KELLY, REMMEL & ZIMMERMAN

February 4, 2009

Re: Project at 72 Walnut Street, Minor Site Plan Application No. 2006-0230

**GRADING & DRAINAGE PLAN**

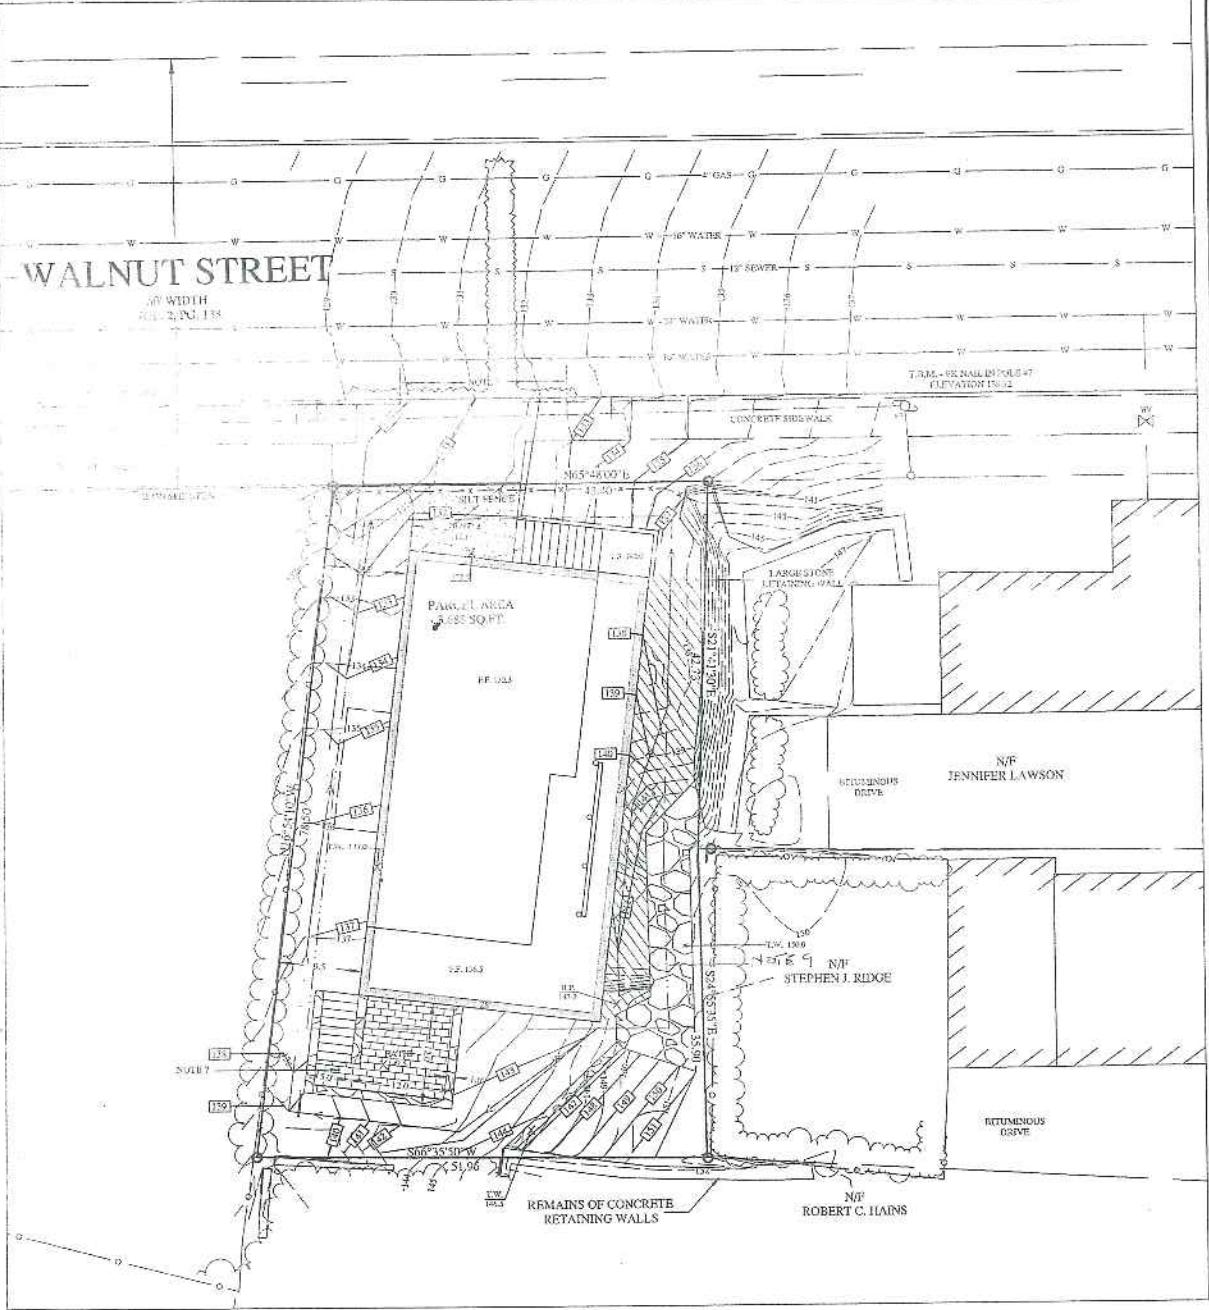
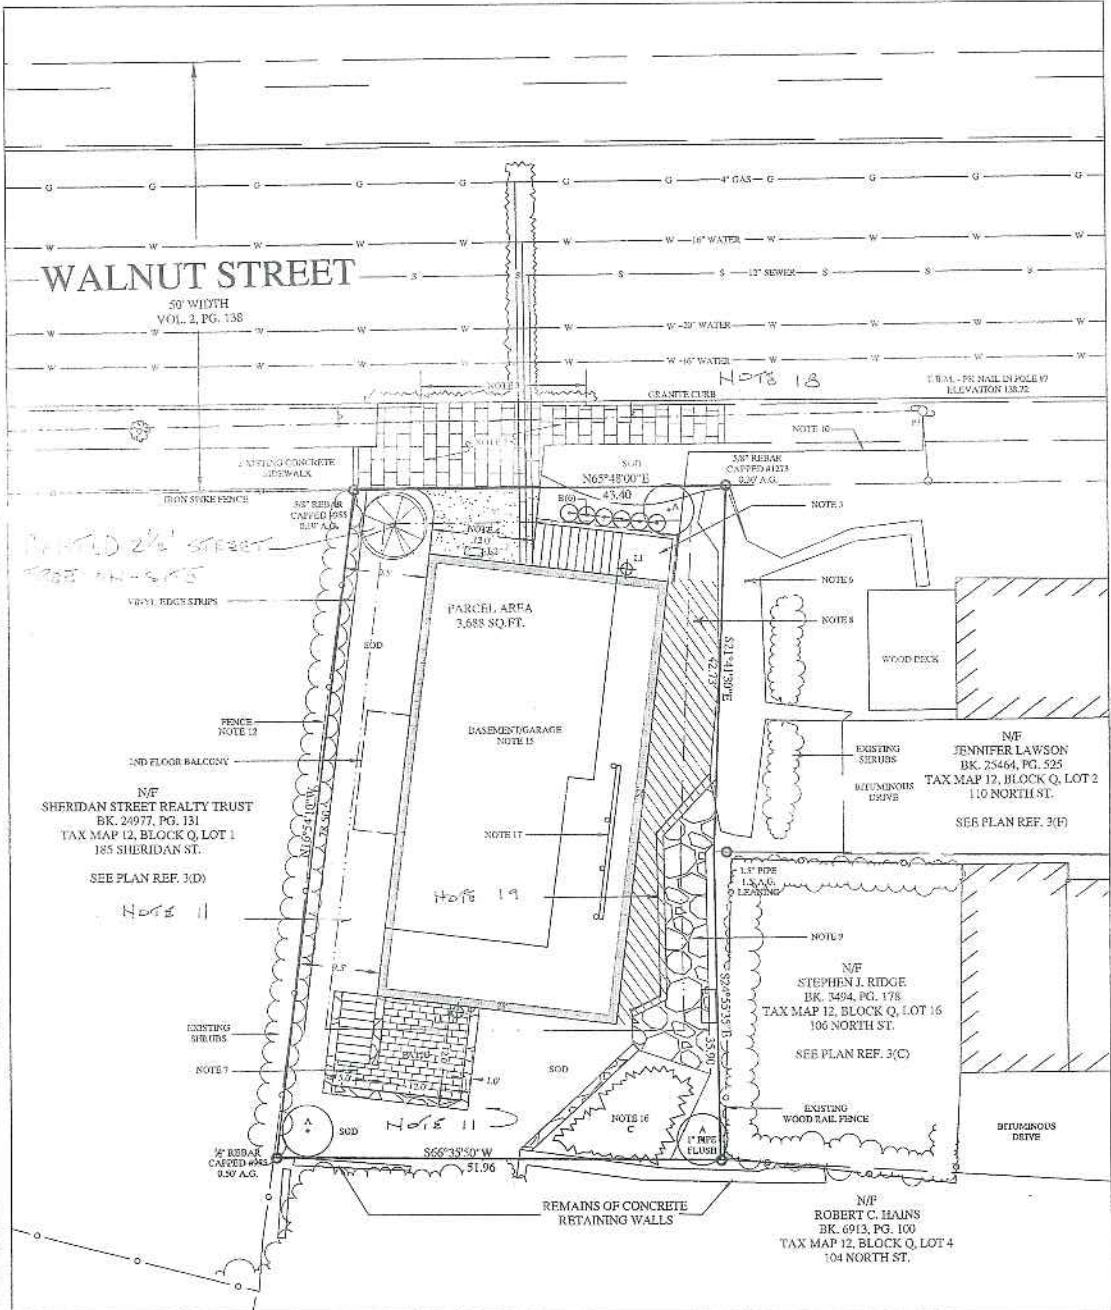
First, I note from the most recent proposed site plan that the structure proposed for the property contemplates a foundation which will be constructed with an exterior wall to be located as near as 5.5 feet from the base of the existing large stone retaining wall. Since the over-excavation which will be required for the construction of this foundation will certainly require an opening that exceeds the anticipated exterior face of the foundation wall, the foundation excavation will be even closer to the base of that retaining wall than 5.5 feet. To my understanding, the applicant has submitted nothing to support the conclusion that excavation of a foundation hole that close to the existing retaining wall will not jeopardize the structural integrity of that retaining wall or the steep

bank which sits behind it. Obviously, if the structural integrity of the retaining wall or the bank behind that wall is jeopardized, significant damage could result to the building on my client's property. I believe that it is the applicant's burden to establish through appropriate engineering submissions, that the proposed location of the structure on the lot can be adequately accessed by construction equipment during the construction phase of the project without damaging the retaining wall or entering onto neighboring properties and (b) that the construction of the project, including the excavation of the foundation, will have no short or long term adverse impacts on the structural integrity of the existing retaining wall. I believe that this requirement is specifically contemplated by the provisions of Section 14-526 of the Ordinance, including, without limitation, subsections (a)(6) and (8).

LEFT ELEVATION

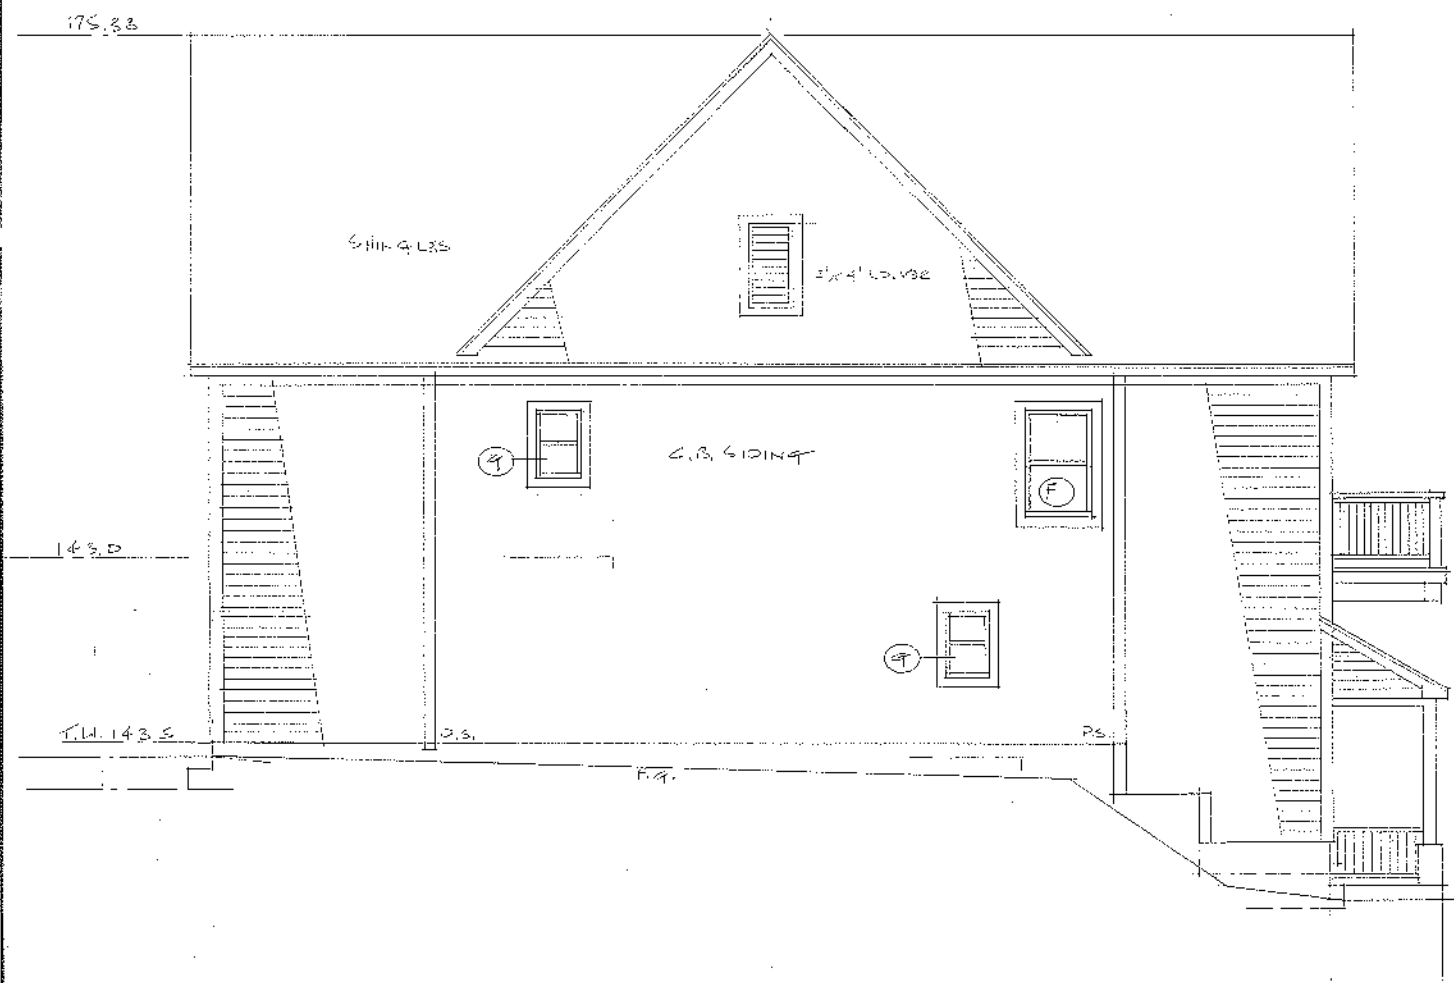
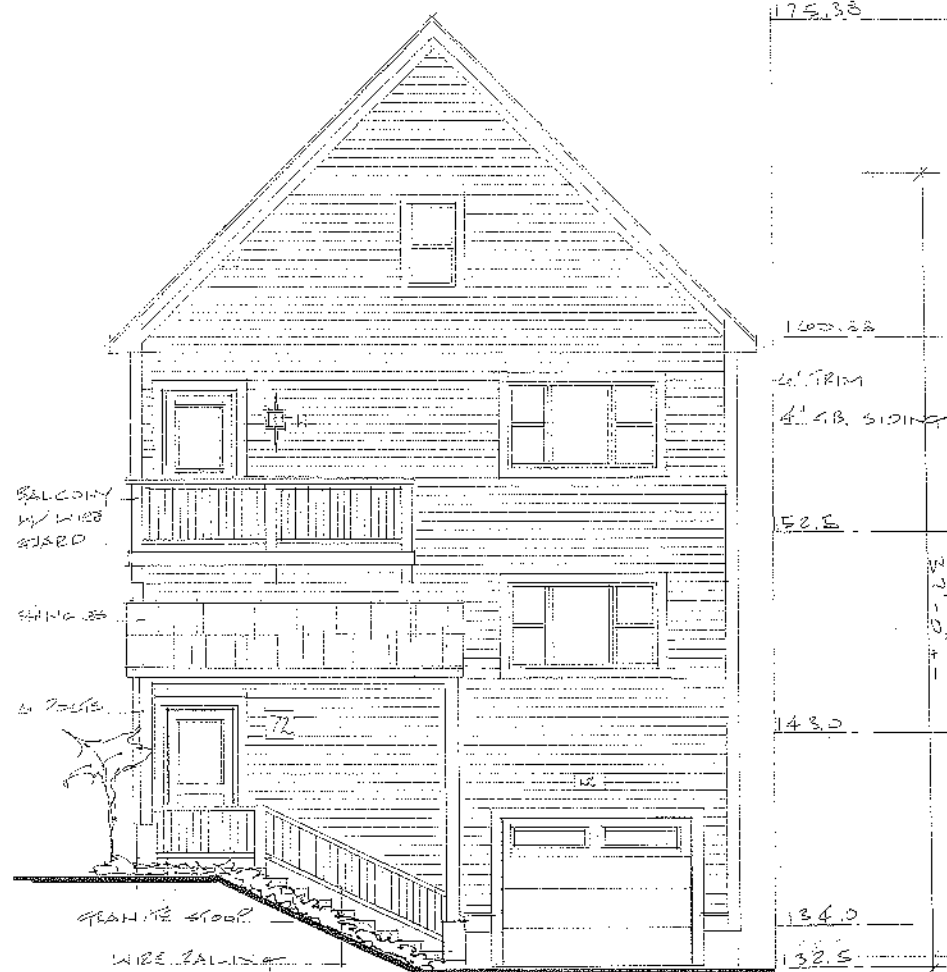
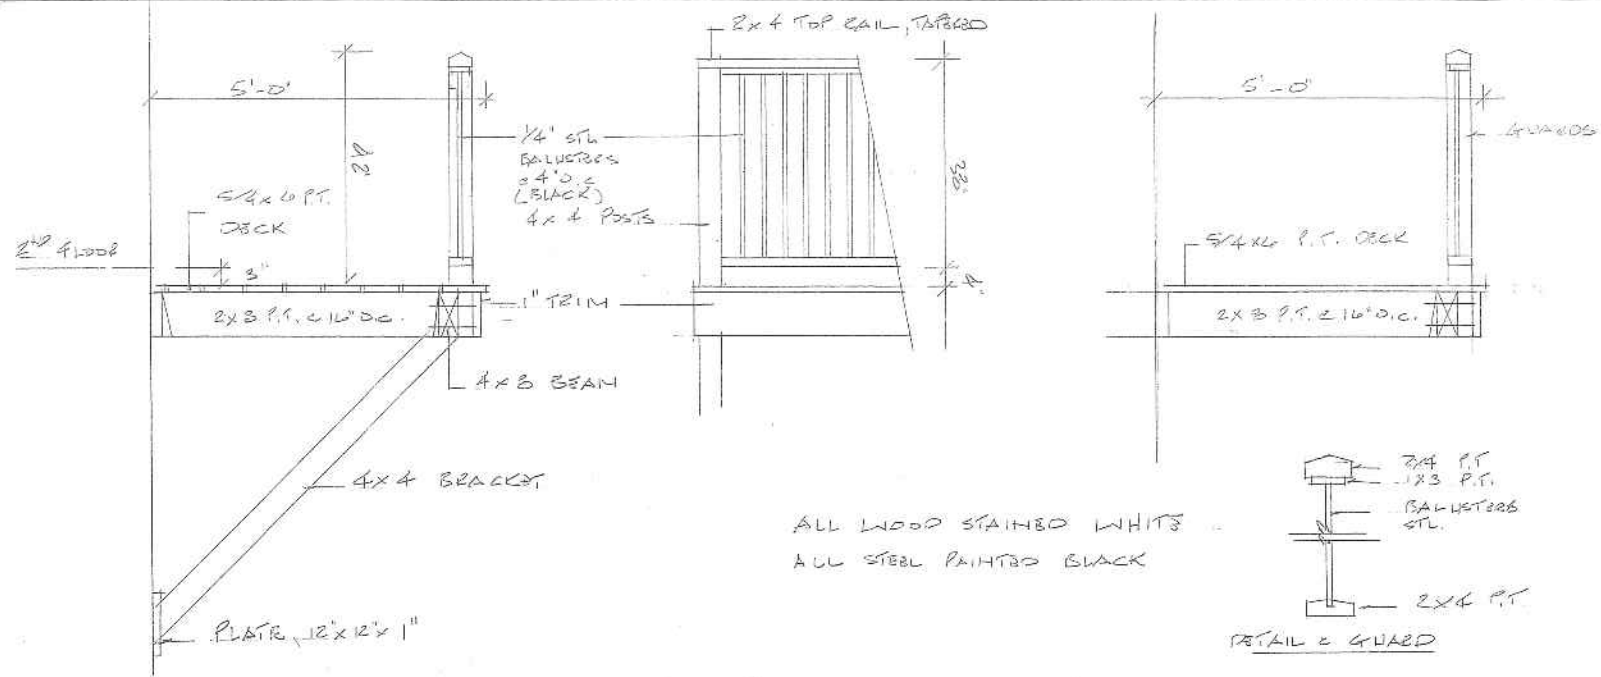
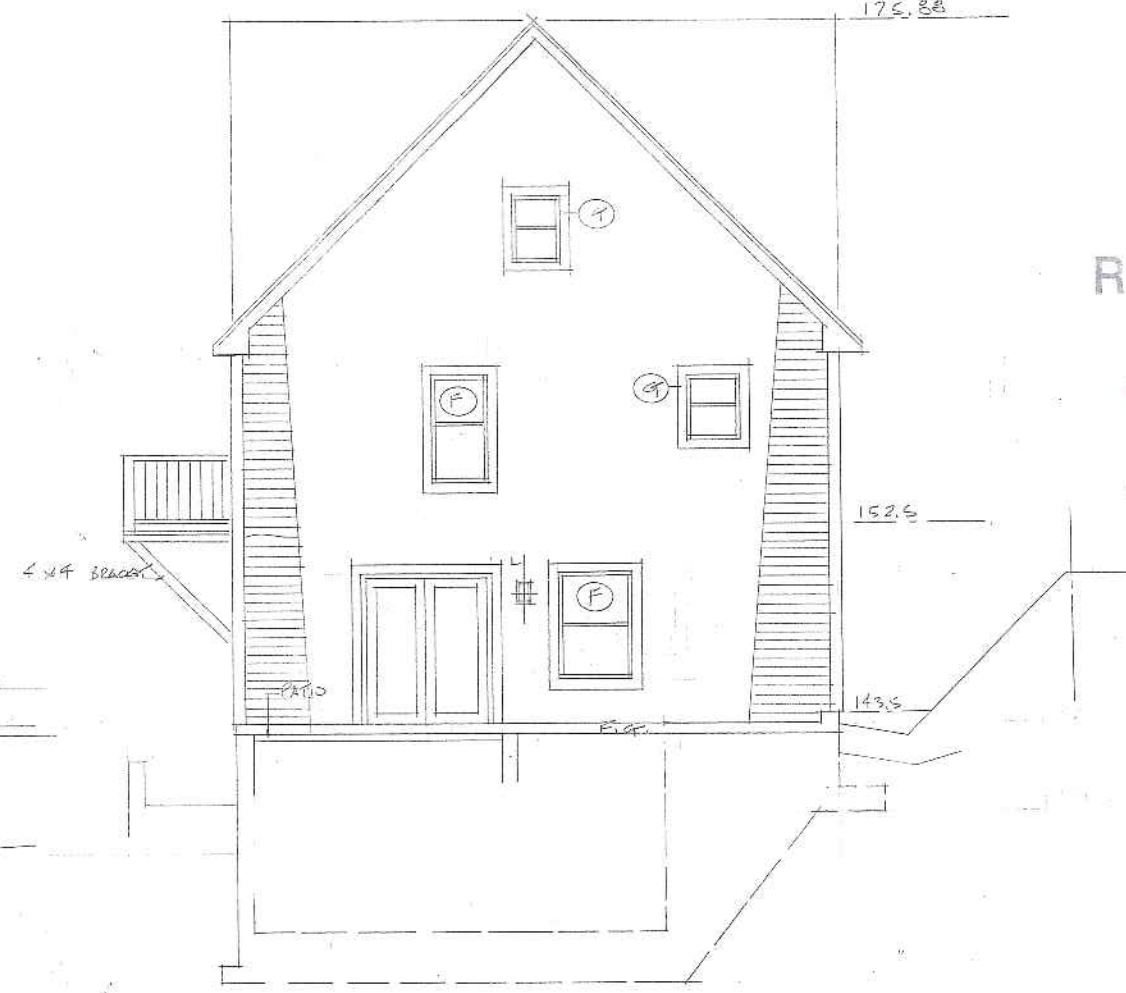
In addition, my review of the building elevations submitted with the application appear to reflect a building height which exceeds the maximum height allowed under Section 14-139(2)(e).
